SHORELINE SUBSTANTIAL DEVELOPMENT PERMIT EXEMPTION

Two story garage with bathroom

SX-20-00004

SITE PLAN
SCALE 1" = 15'

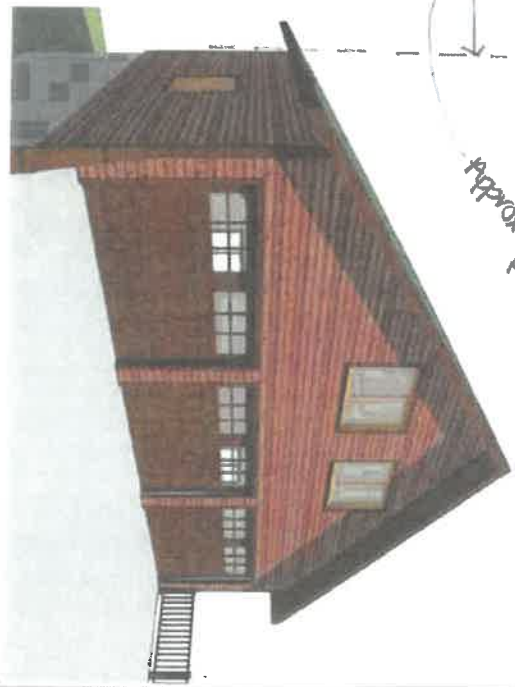
1. All work shall substantially conform to the specifications of the application materials submitted to CDS on January 16, 2020 and the amended site plans received by CDS on February 27, 2020 and March 23, 2020. Please note that the site plan you submit with your building permit application shall match the March 23, 2020 site plan with one addition, the 100 foot shoreline buffer and 15 foot structural setback from the OHWM of Lake Kachess shall be added to the two dimensional site plan and not just shown on the profile view.
